MEMORANDUM

TO: Nell Donaldson, Planner
FROM: Lauren Swett, P.E.
DATE: May 5, 2017
RE: 1210 Brighton Ave Hotel Redevelopment, Site Plan Amendment

Woodard & Curran has reviewed the revisions to the proposed hotel redevelopment project located at 1210 Brighton Avenue in Portland, Maine. The project was previously approved, and revisions have been proposed to the building and site features

GRADING DETAIL PLAN

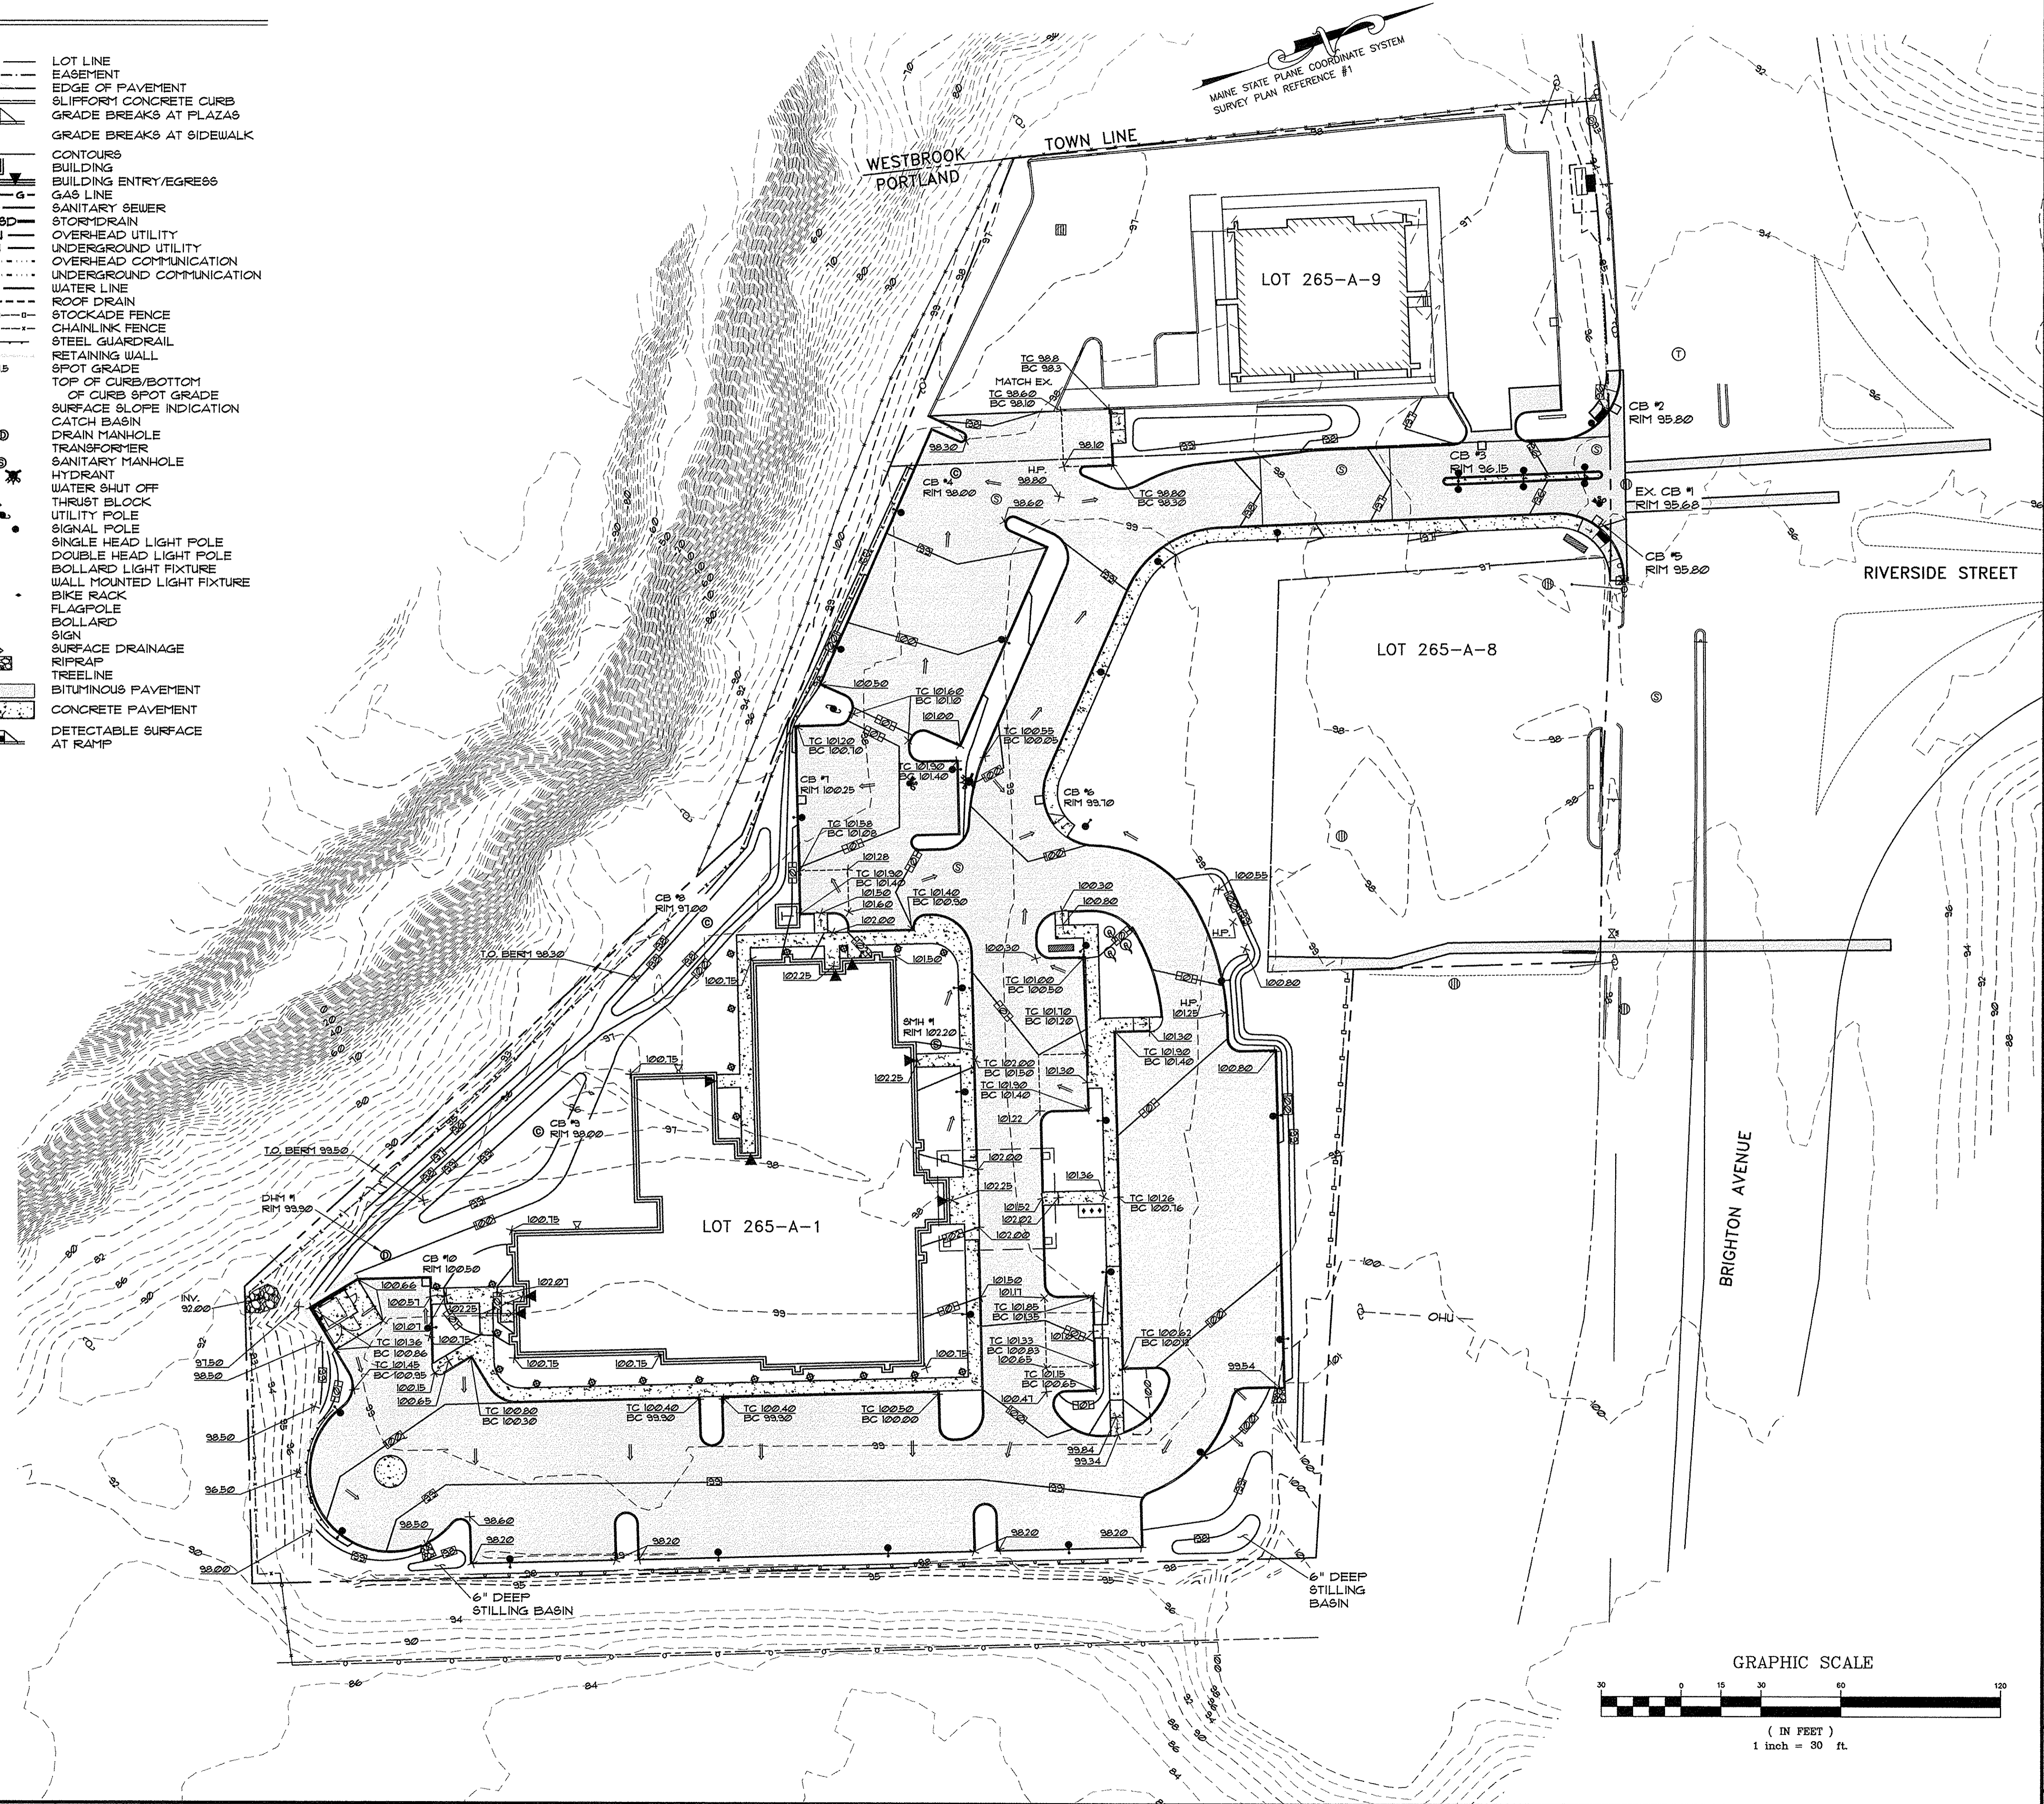
- The Applicant has changed the stormwater drainage configuration at the eastern end of the property. We have the following comments on this change.
 - Where drainage was originally directed to breaks in the curbing, the curbing has been eliminated and stormwater can now drain in between curb stops installed along the length of the pavement at the eastern end of the property. It appears that there are also two small curb openings on the northern and southern ends of this section of pavement. The Applicant should ensure that adequate stabilization is provided to prevent erosion from the two remaining openings and the multiple openings between the curb stops.

- A drainage easement was originally proposed for rip rap swales that conveyed drainage onto the adjacent City property. The rip rap swales have been eliminated, and the Applicant has indicated that the drainage easement is no longer necessary. Stormwater from the a relatively large section of the parking lot will continue to flow to the adjacent property owned by the City and maintenance of this area for erosion should remain the responsibility of the Applicant. The City should verify whether a stormwater easement should be put in place in this area.
